**ATP Locomotive Workshop (Bays 5 - 15) (SSD-8449-Mod-4)
Request for Additional Information**

I refer to the Response to Submissions (RtS) for changes to the internal design and layout of Bays 5 – 15 of the Locomotive Workshop (SSD-8449-Mod-4).

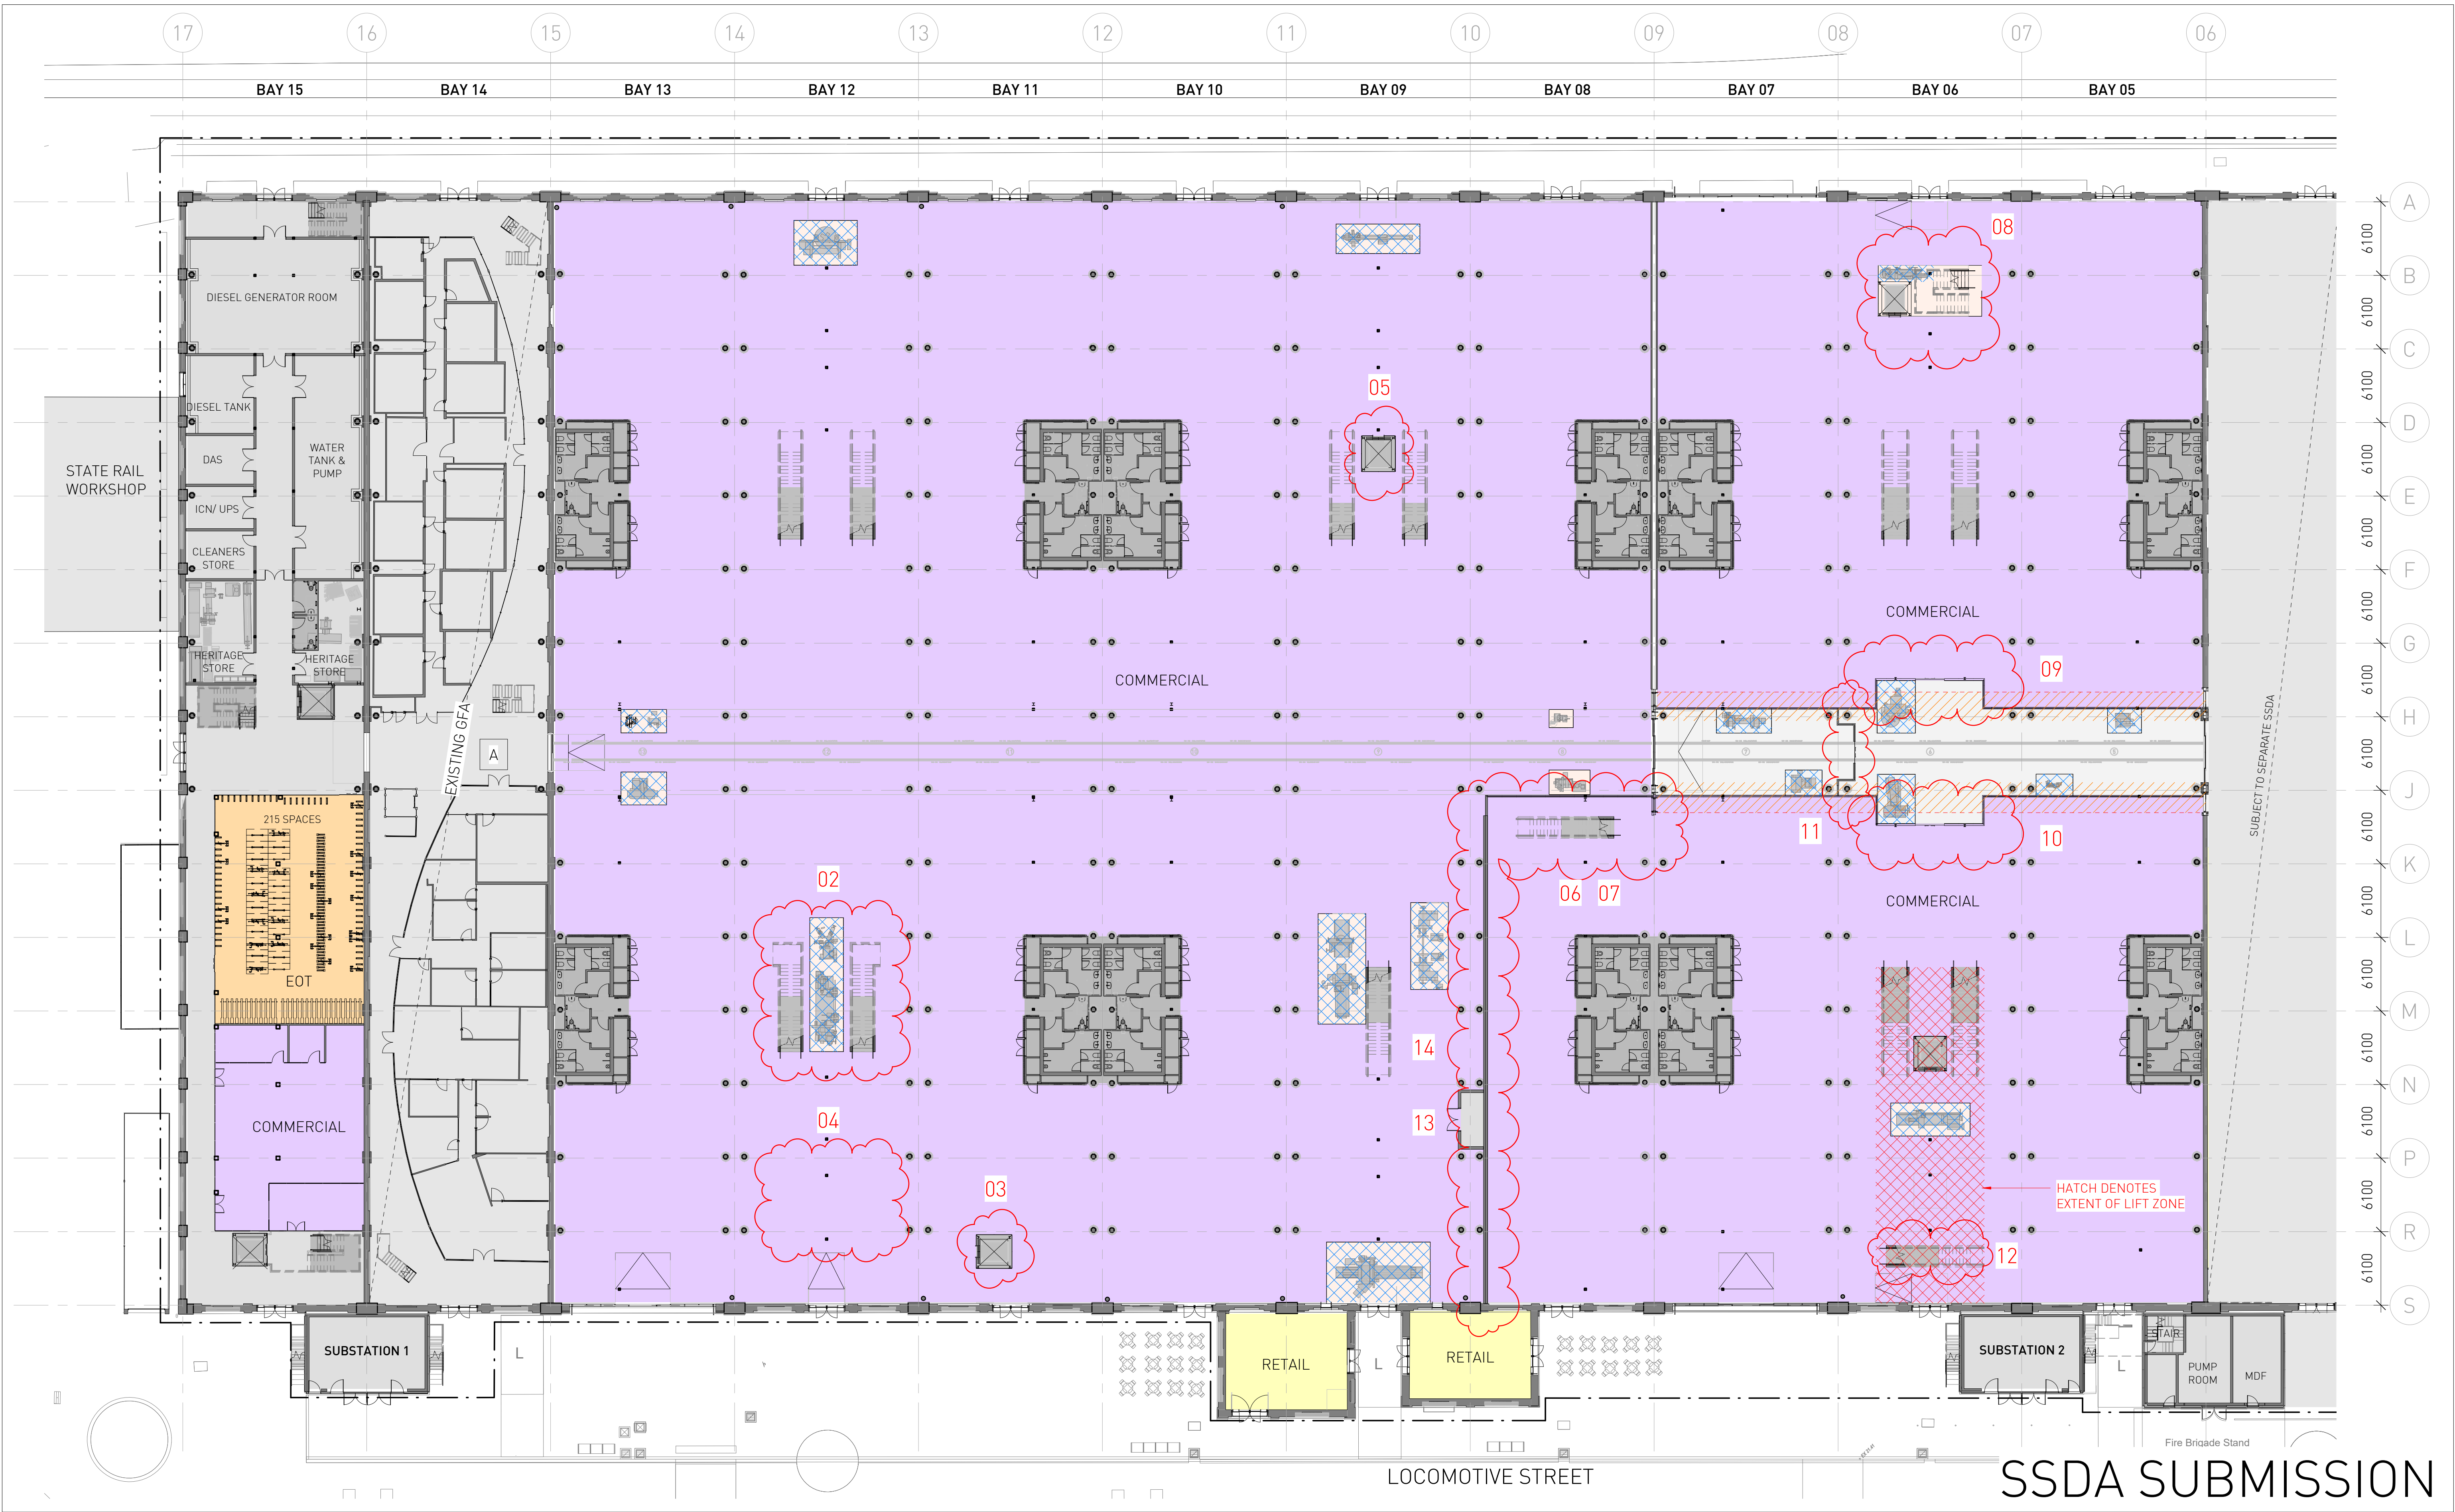
1. Sliding glazed door on gridline 8:

While the Department notes the glazed door is proposed to comply with the BCA requirement that in the event of a fire/ emergency, members of the public be within 20 m of a point of choice egress, the Department raises concern that it:

- adds a barrier into the central spine zone, which was a key corridor critical to the original functioning of the building
- limits access to the two moveable heritage items located within the central spine of Bay 7
- is unclear, who would use or access the area between the sliding door on gridline 8 and the wall on gridline 9.

The Department therefore requests you consider an alternative design response instead of the proposed sliding glazed door on gridline 8. The alternative solution should not result in a visual or physical barrier or restrict public access along the central spine.

③ SK_0851 GRID 8 GLAZING - GROUND FLOOR PLAN
1:50

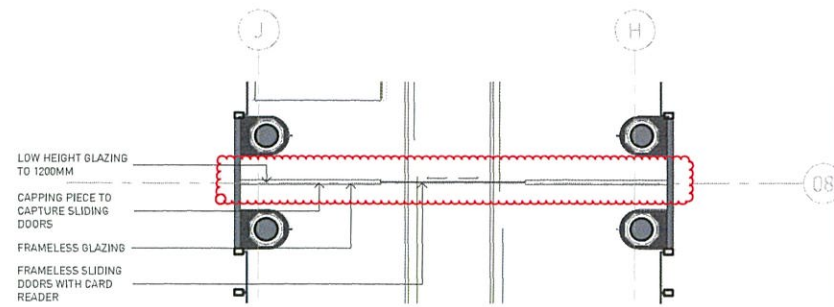
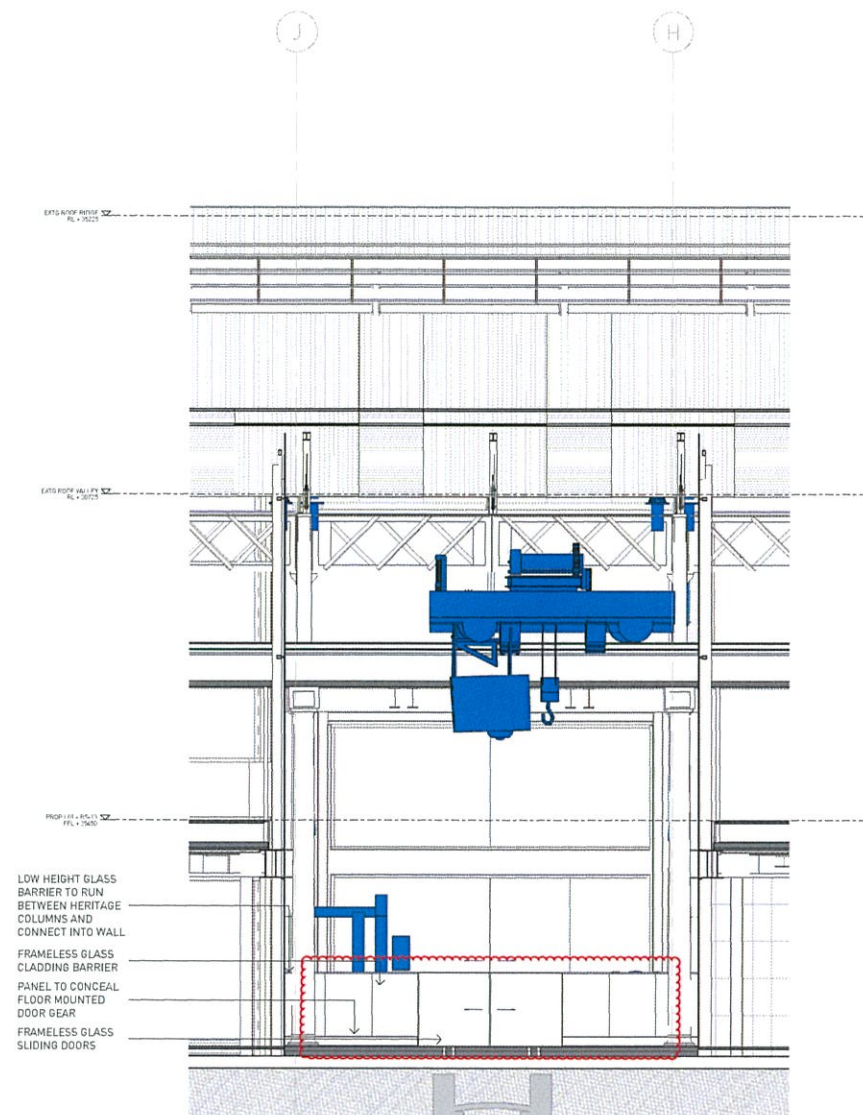
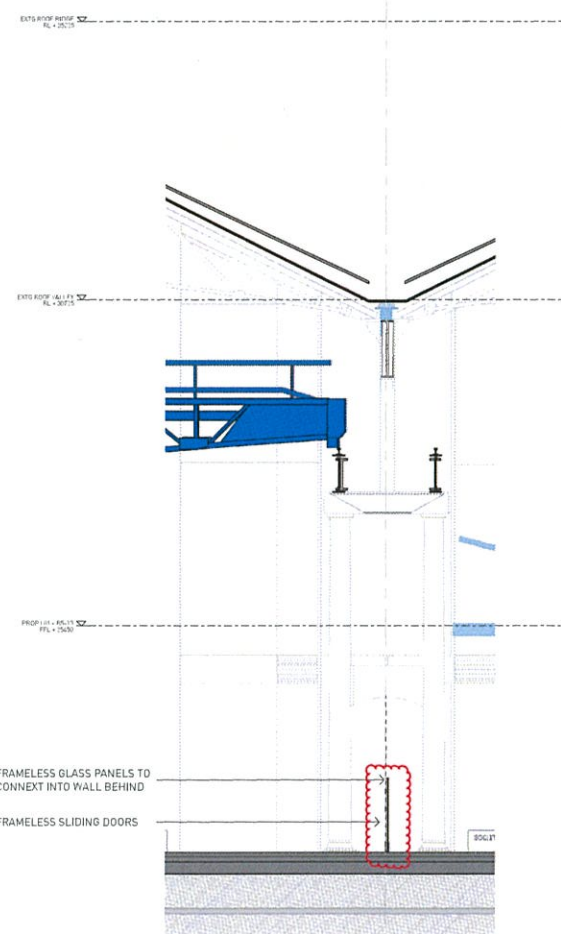
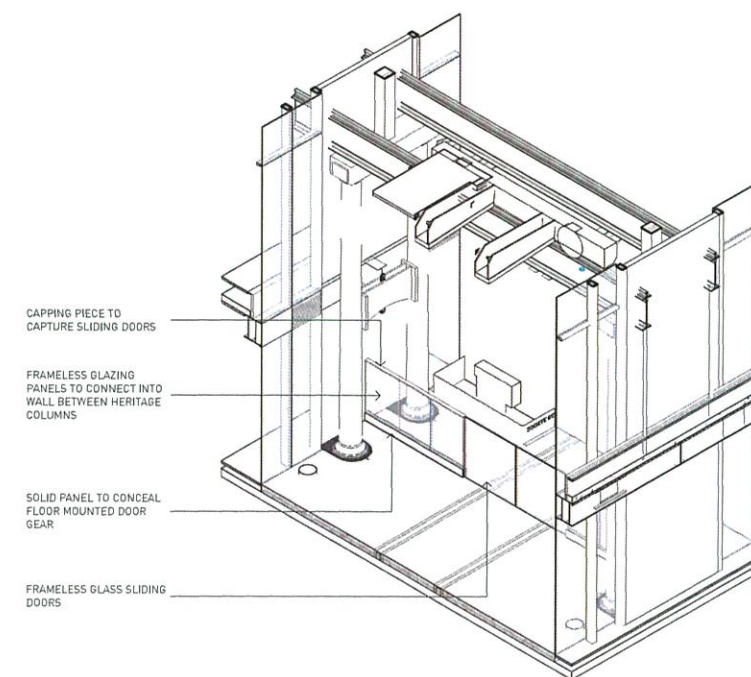
As both Heritage NSW and Council raised concerns with the sliding glazed door, it is recommended you consult with both agencies in developing an alternative design response.
